Recommendation Report for Planning Permission for Works or Extension to a Dwelling

REF NO: WA/113/18/HH

LOCATION: 9 Orchard Way
Fontwell
Walberton
BN18 0SH

PROPOSAL: Two storey rear extension, first floor side extension & conversion of garage to habitable use.

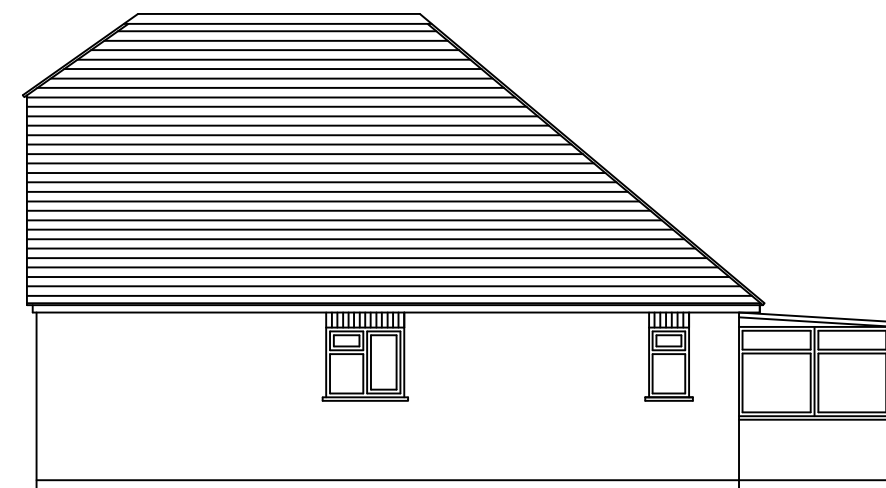
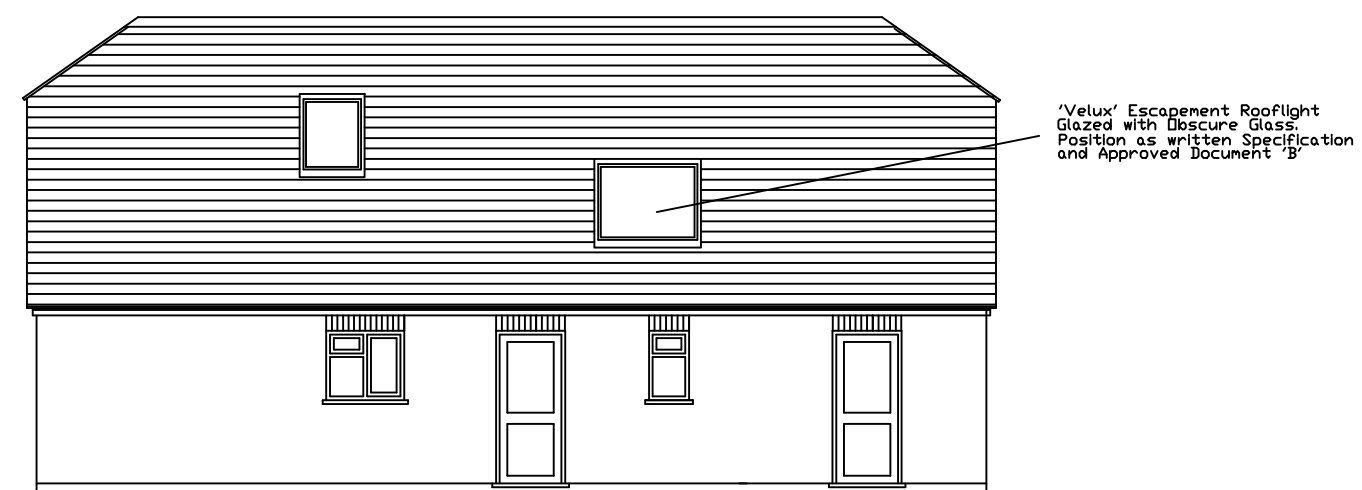
- If the existing glass to velux window on the eastern elevation is changed to obscure then we have no objection.

To the eastern side elevation there will be 2 additional doors to the ground floor. There will also be an additional velux however this will be obscured as shown on the plan to ensure there is no loss of privacy to neighbouring amenity. In order to reduce any adverse overlooking upon the east it should also be fixed shut above 1.7m. To the western side elevation there will be 2 windows to the ground floor. These are again not considered to increase overlooking from that which is already possible.

- 3 The velux window on the rear eastern elevation of the building shall at all times be glazed with obscured glass and only openable at a high level, at least 1.7m above finished floor level.

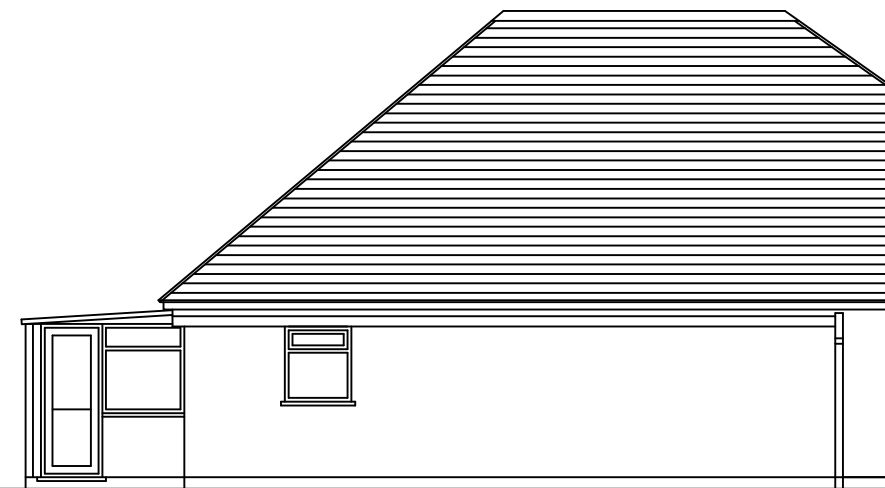
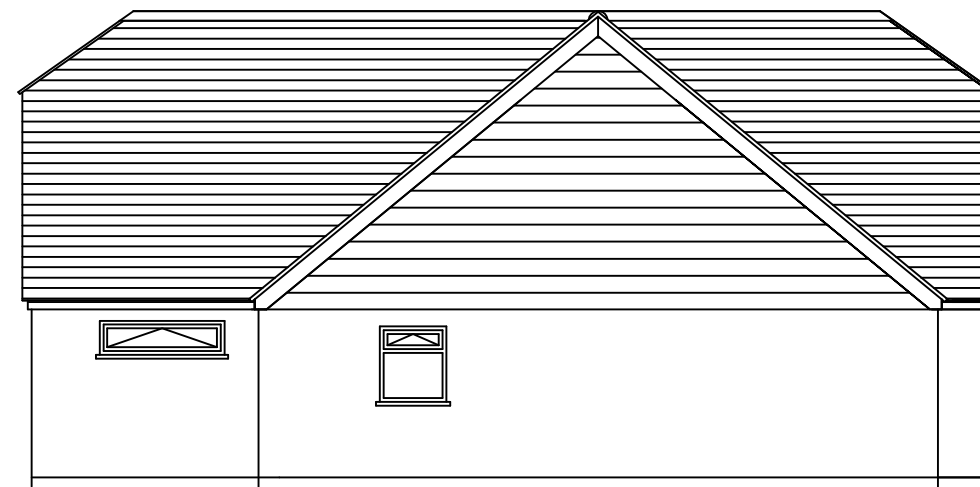
The proposal is visible from the street scene as a result of the alteration to the roof. The extension over the garage currently has a barn end hip roof and this will be altered to form a full gable roof.

The addition to the roof to form a gable end is modest in scale and as a result does not appear overbearing or overly dominant upon the locality. The surrounding properties are of a mixed style and design and it is not considered out of keeping with the area.

The proposed gable end to the garage extension at the western elevation is modest and due to its siting and separation distance is not considered to give rise to any adverse impacts in terms of overbearing or overshadowing upon neighbouring amenity at No.7.

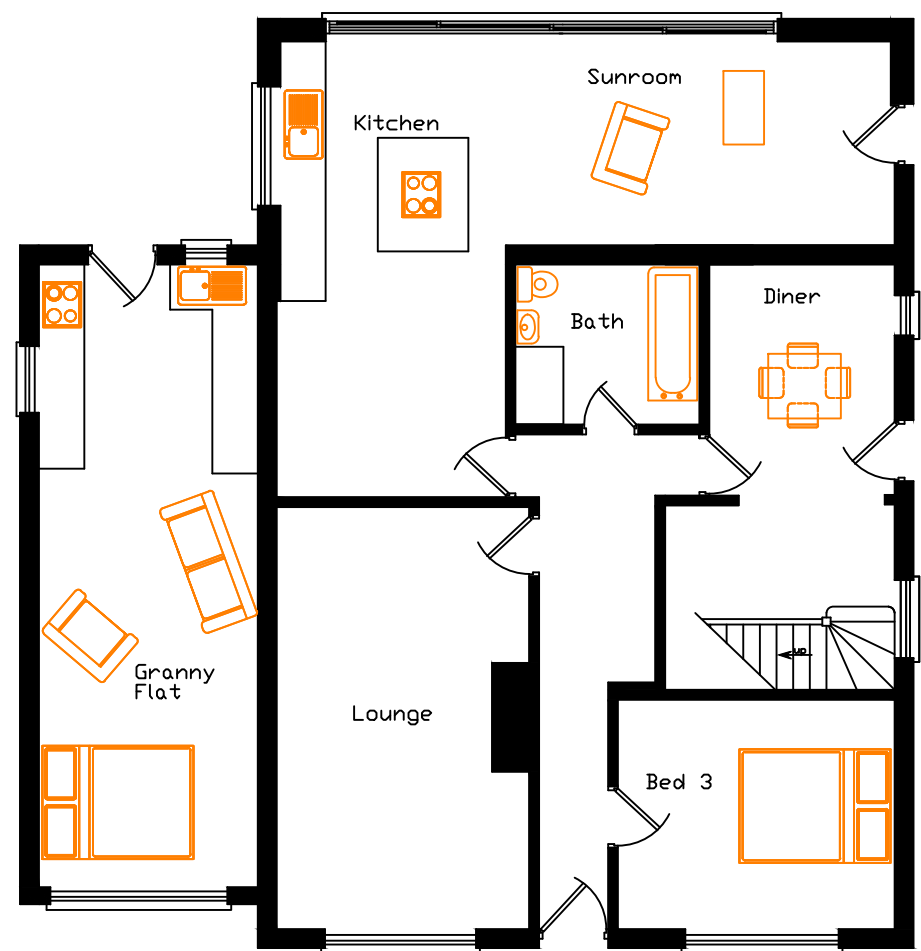
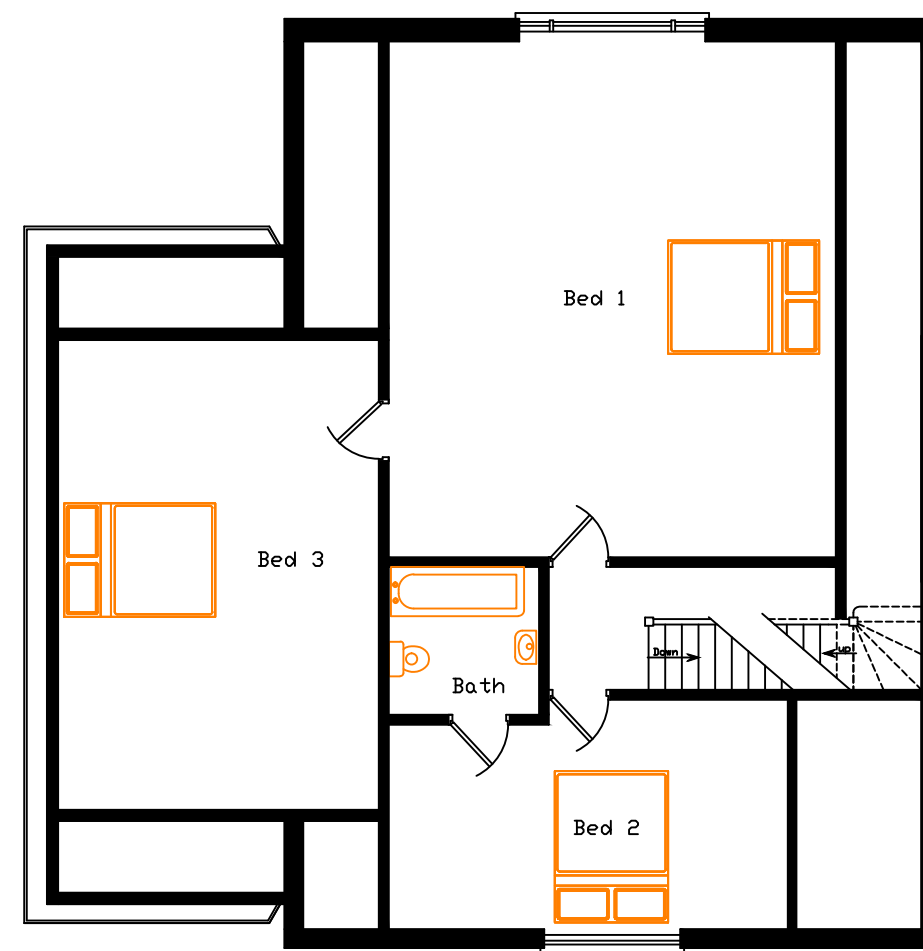
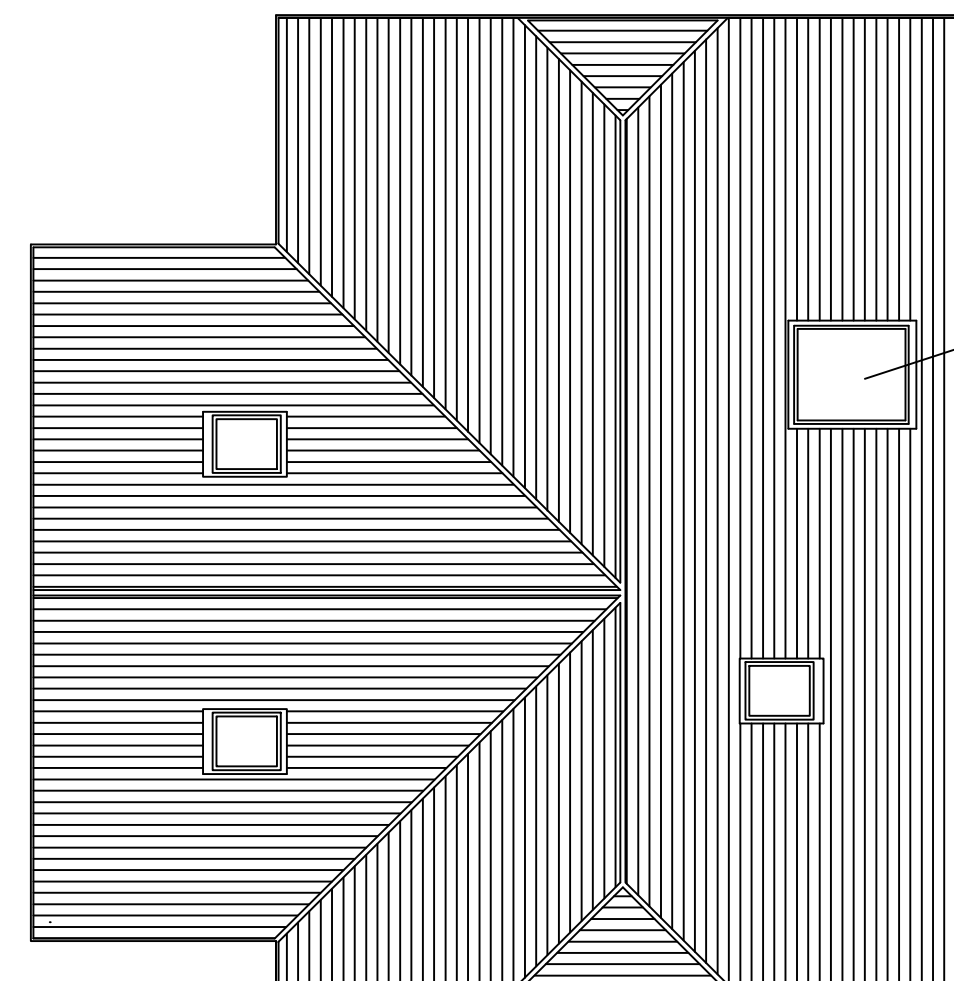
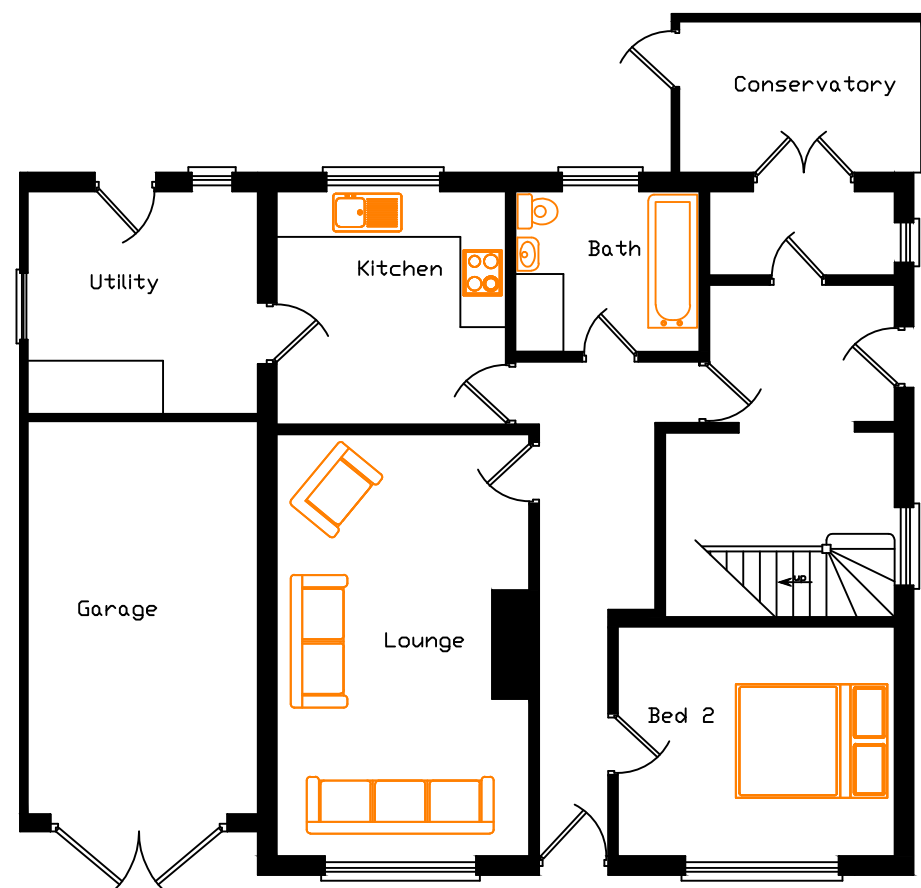
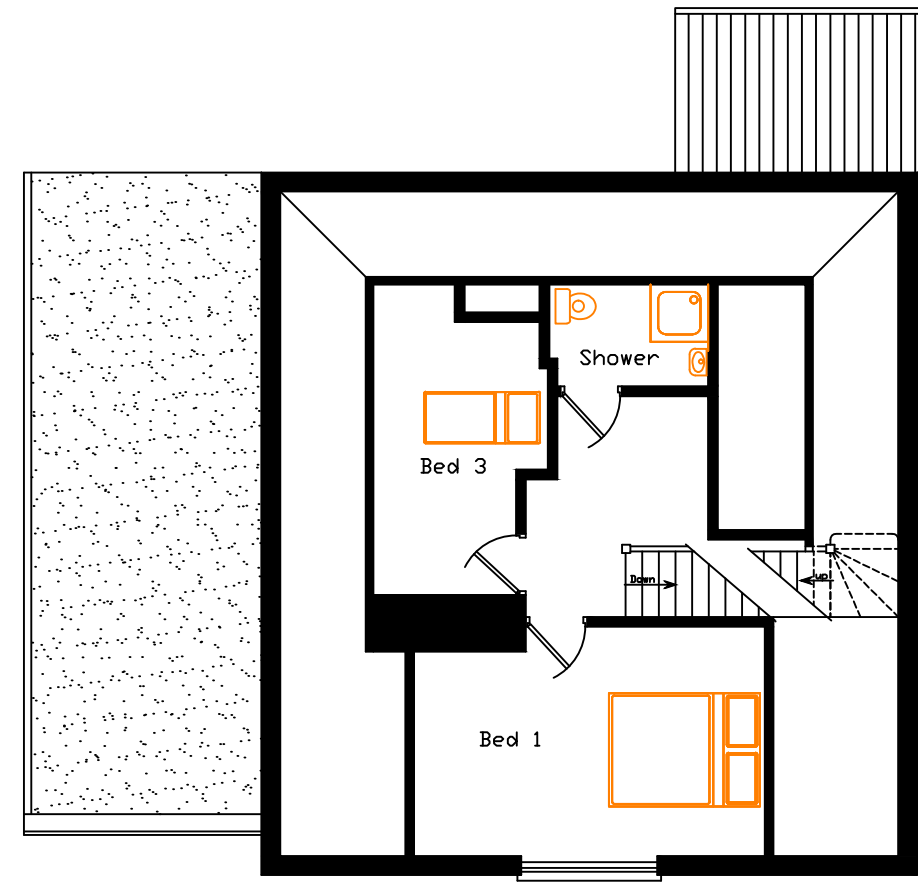
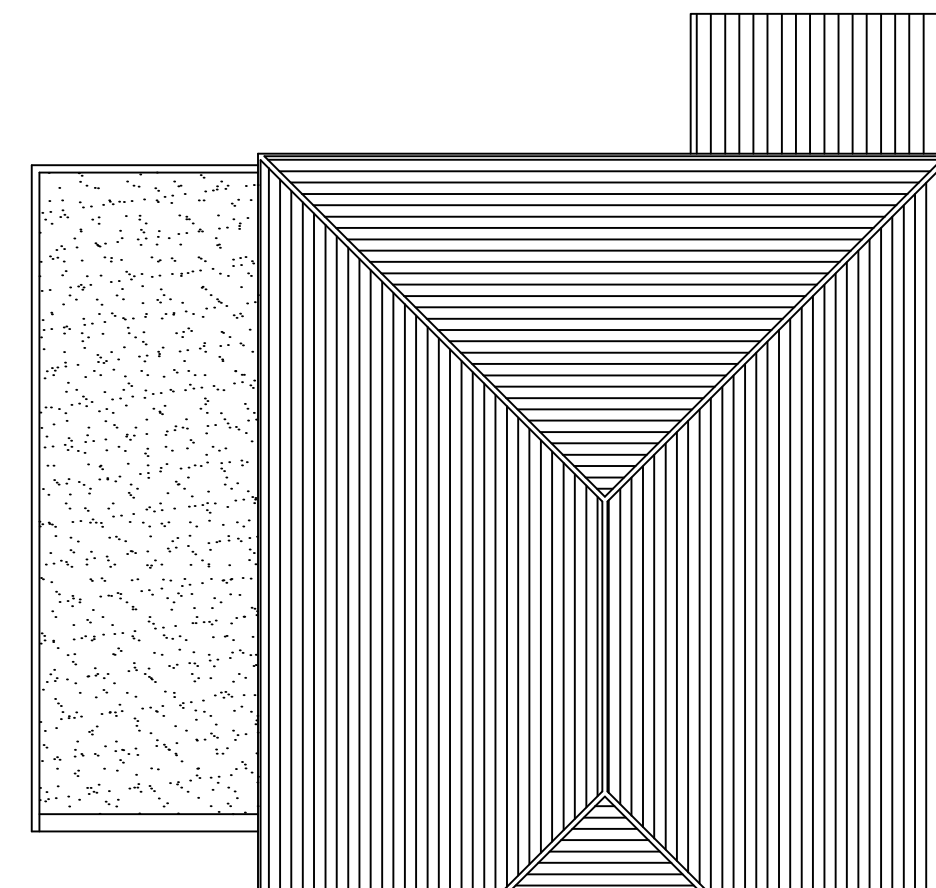
a refusal is justified. A velux will also be installed facing towards the rear however again will be obscured as shown on the plan.
